Application for Householder Planning Permission

Development Alterations & first floor extension, providing a reduced garden room on the ground floor, together with conversion of garage to a gym & 2 new bedrooms, study & bathroom to first floor. Removal of existing pitched roof & replace with lower mono pitched roof

Location Sandgate House South Strand East Preston Littlehampton

Thank you for the information you have sent following my previous letter. Unfortunately I am still unable to accept the application as valid until the following matters are resolved:-

East Elevation

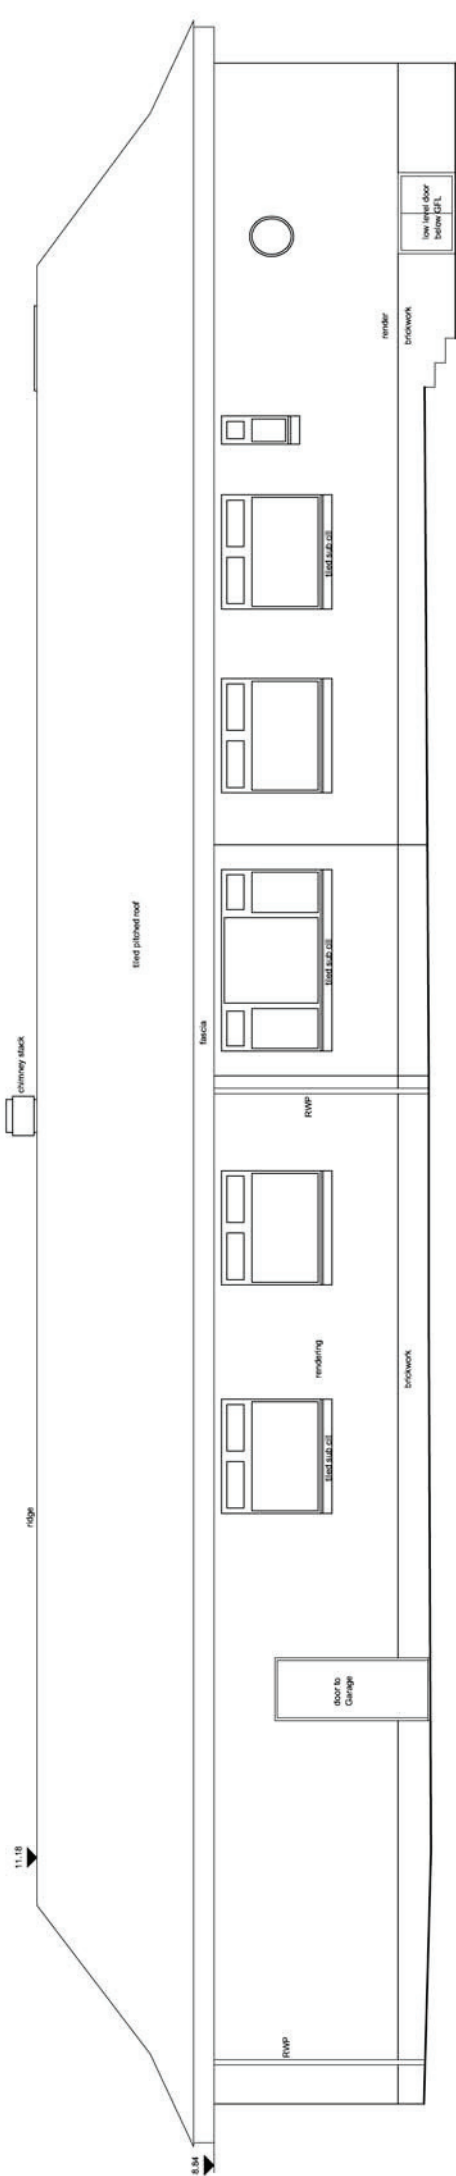
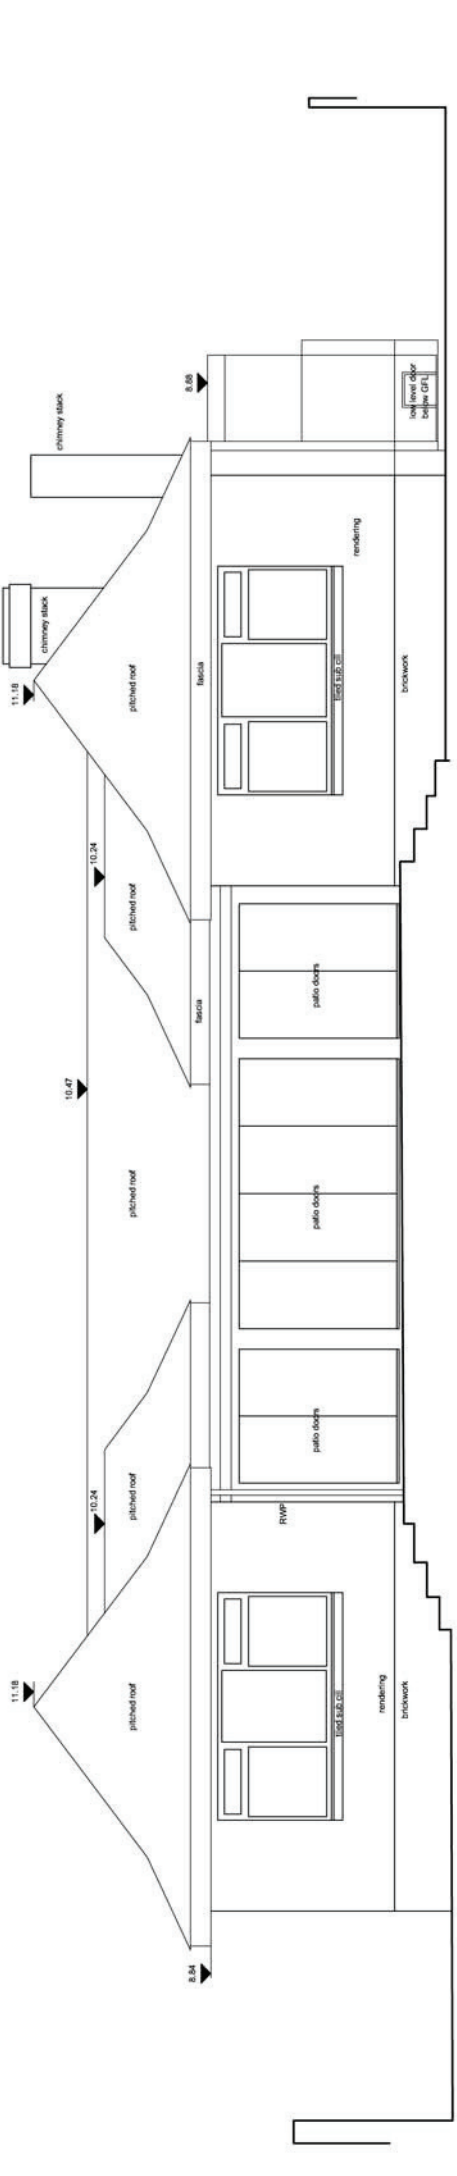
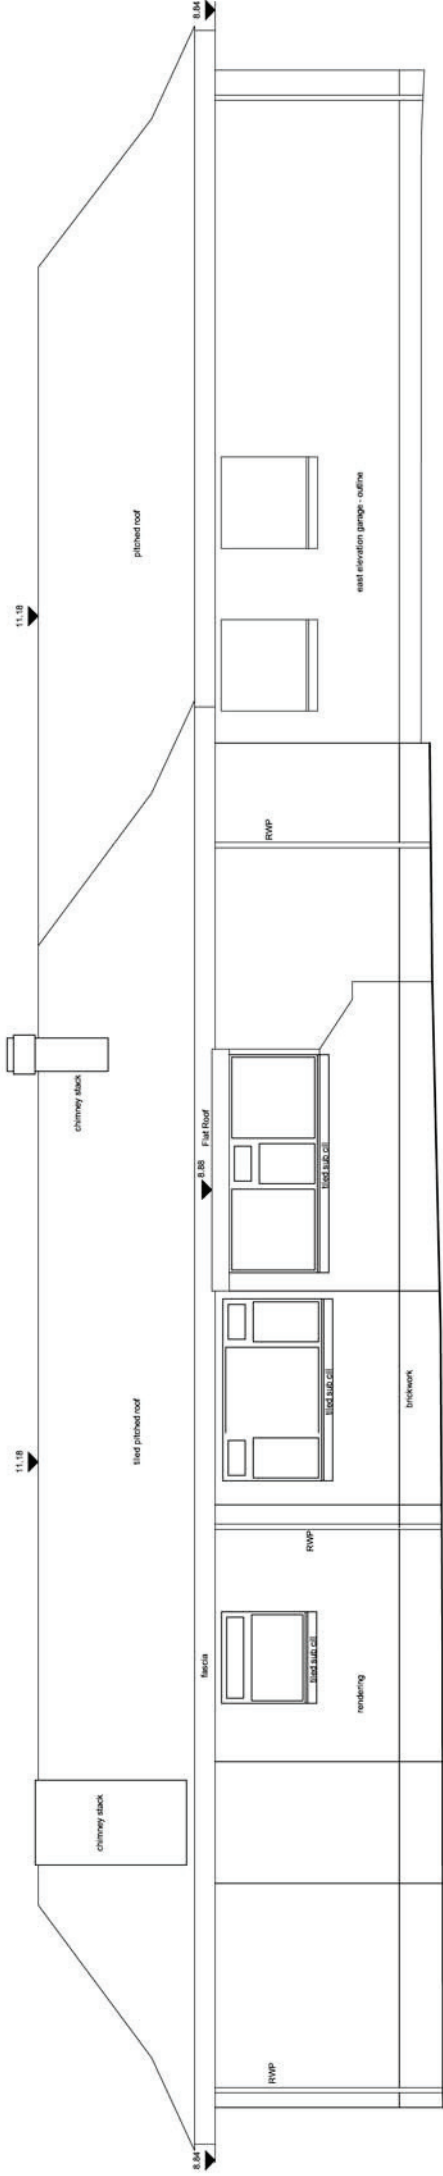
Please provide 1 electronic or 3 paper copies of revised existing east and west elevations. They appear to be labelled incorrectly (the east elevation is marked as west and vice versa). Please amend.

1207 SK28 A
Sandgate House, East Preston
Location & Block Plan
June 2012
scale: 1:500/ 1:1250

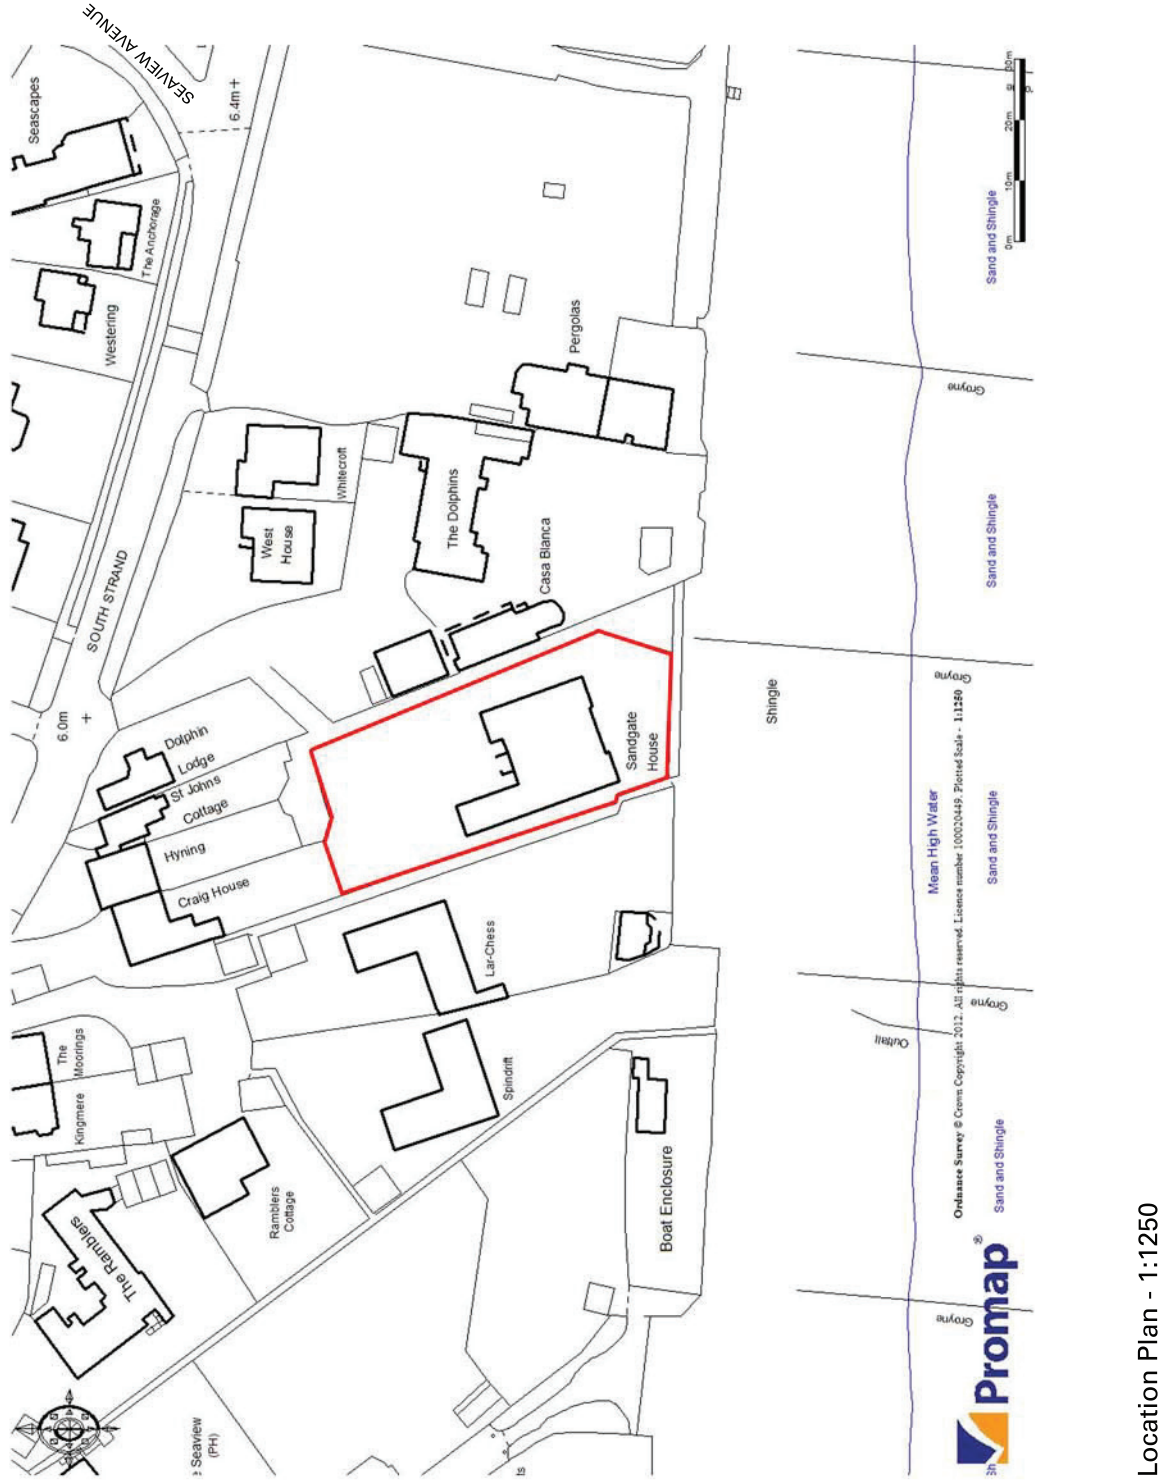
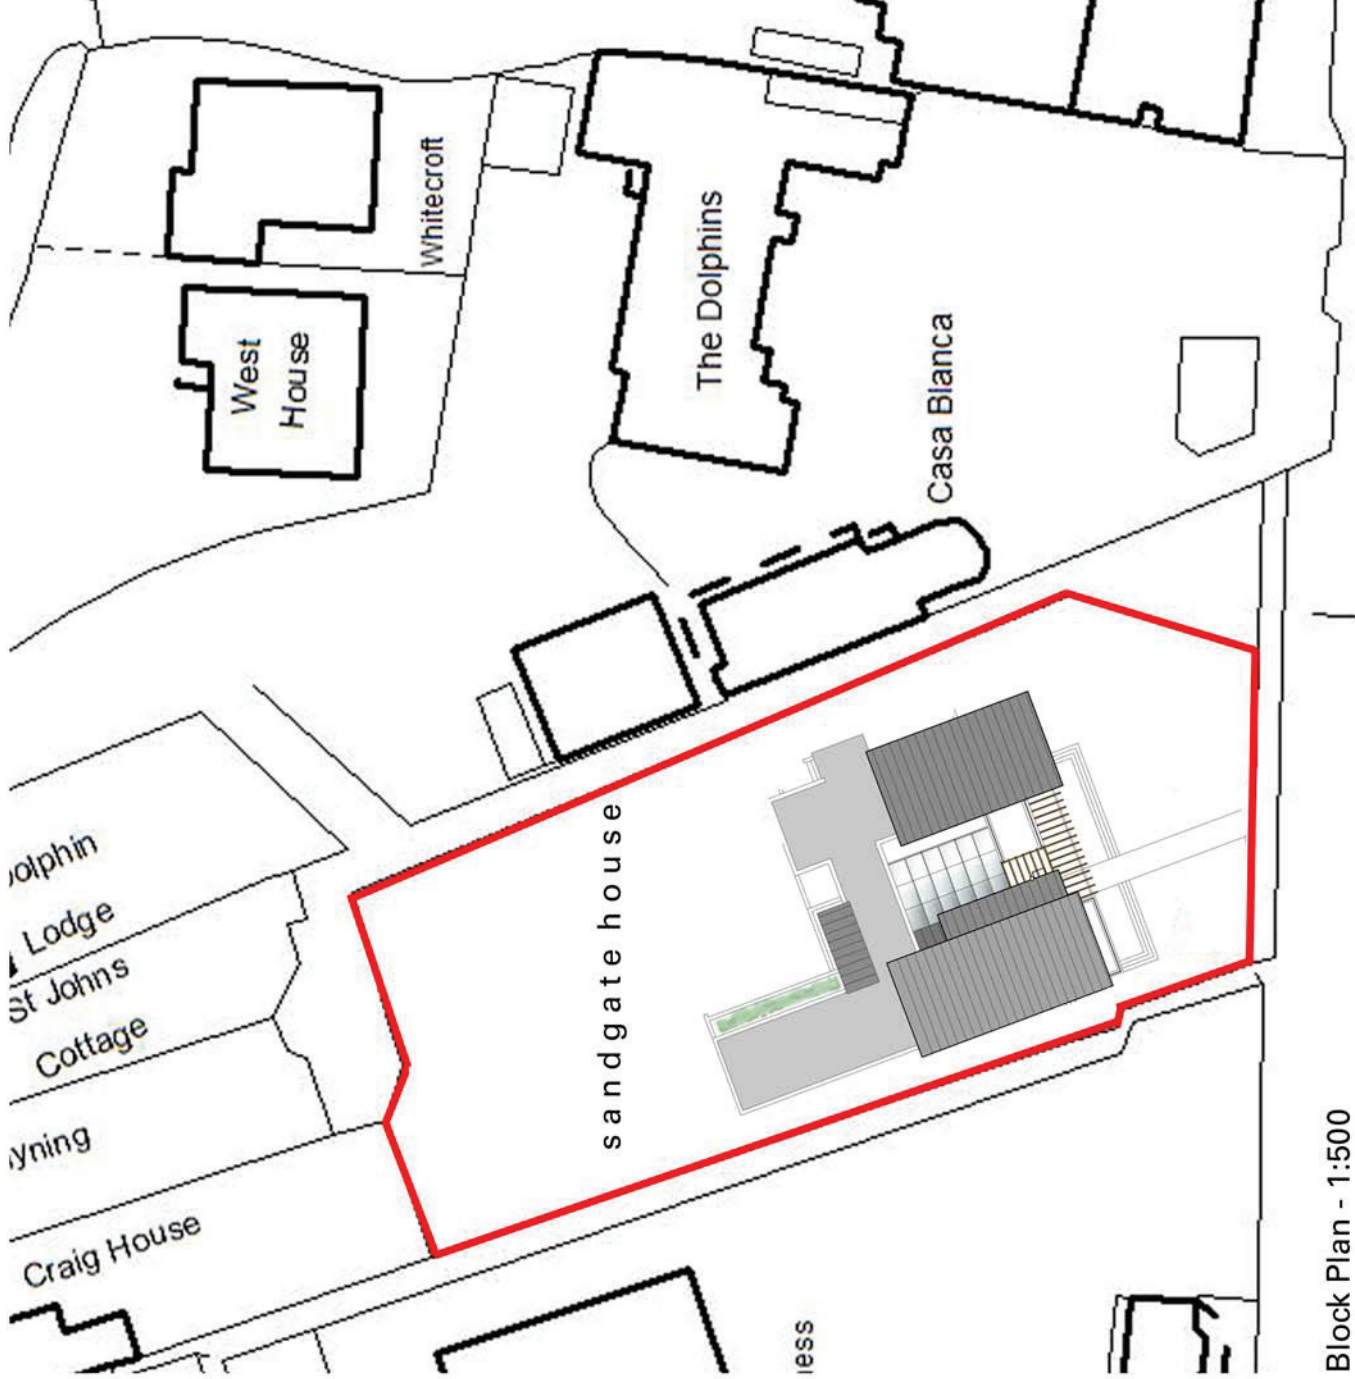
I require 1 electronic or 3 paper copies of a revised location plan showing a second named road, in accordance with the guidance notes available on our website detailed below (click on National List).
